# ***City of Albuquerque***

February 22, 2001

**Re: Ammended Grading Plan Submittal for Building Permit Approval for 501 Morris NE -  
Dominion Plaza, Engineer's stamp dated 10-12-00 (K-21/D9G)**

revisions	
△	10-12-00 EXPAND PARKING LOT
△	
△	
title:	
drawn by	BJG
reviewed by	RLB
date	10/11/00
project no.	99S06A102
drawing name	
GRADING PLAN	
sheet no.	
C2.0

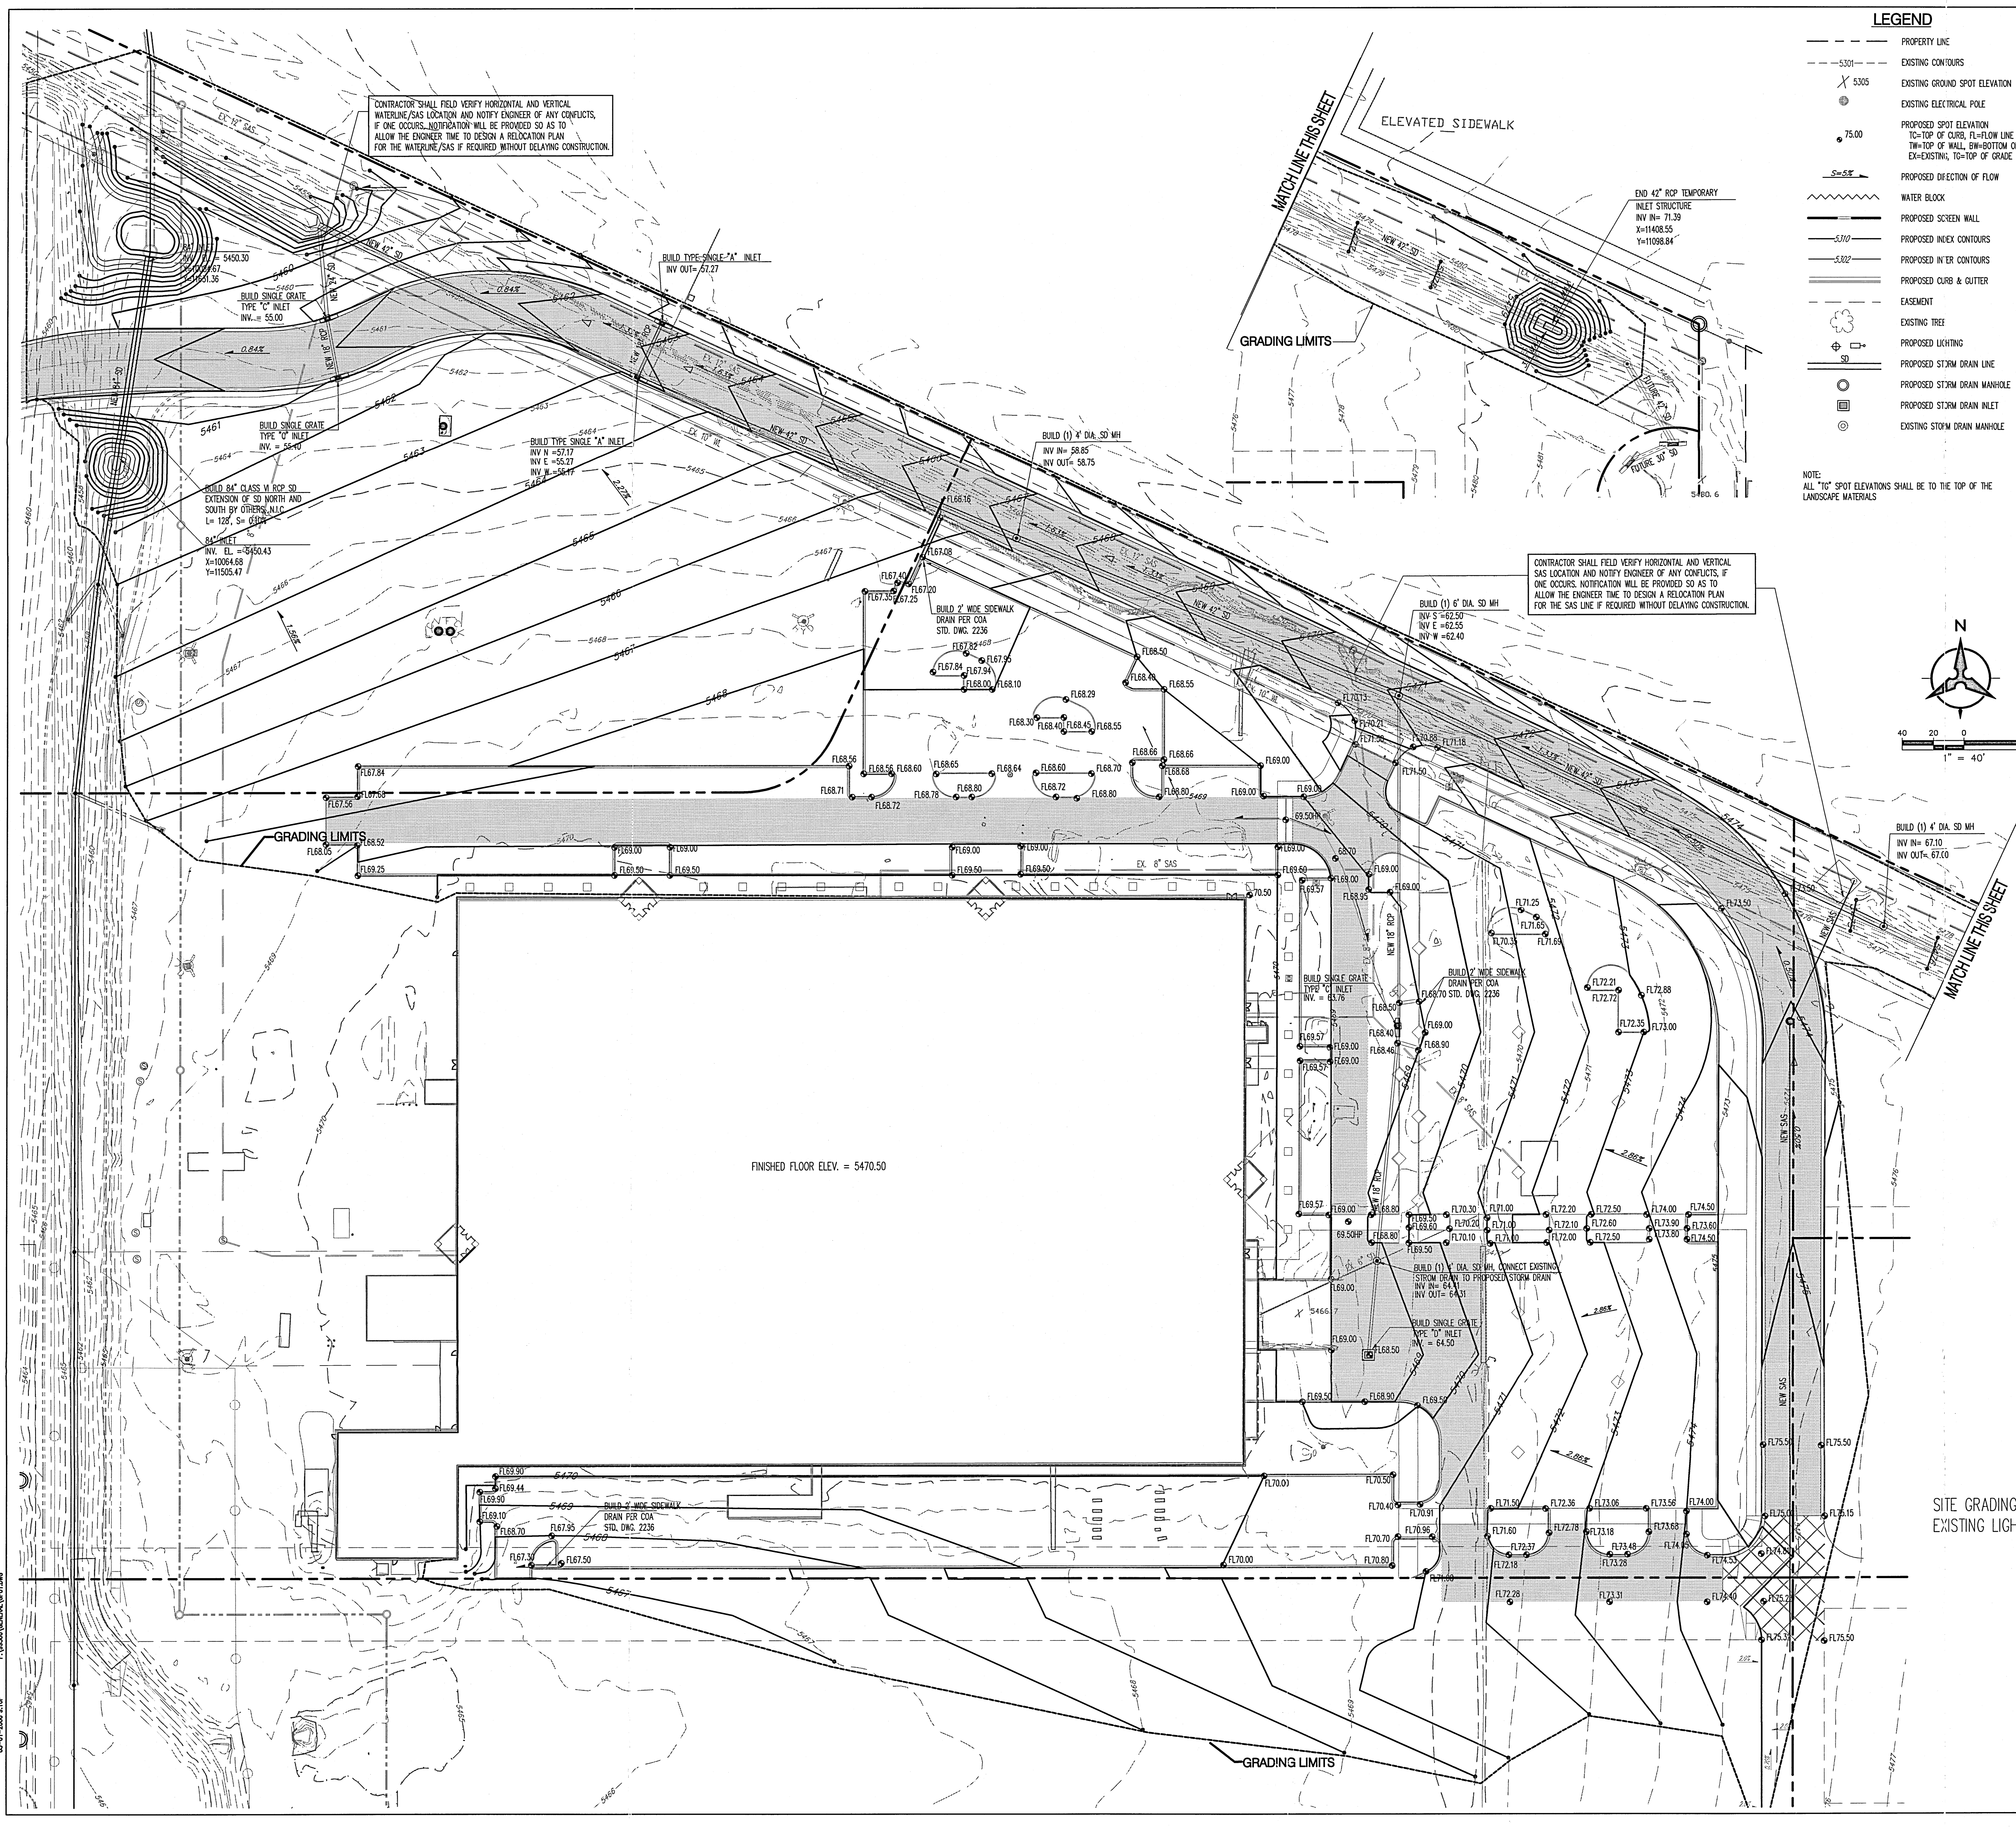
1. Call out the inlet shown at the curb in the northwest corner of the parking lot.
2. Call out the top of grate elevation for all new inlets.
3. The "FUTURE" 18" & 24" storm drain lines conveying the parking lot flow should be labeled as "NEW."
4. The "NEW" 42" storm drain parallel to I-40 should be labeled as "EXISTING."
5. Please label the drainage & utility easement that contains the 42" SD.

I understand from our conversation on February 21, 2001 that 128 feet of the 84" storm drain along the west side of the property is to be built with this project to convey the existing channel flows under the access road. The rest of the 84" (both north and south of the access road) is not finalized due to pending plans for the expansion of Wal-mart and Sam's Club located southwest of the project site.
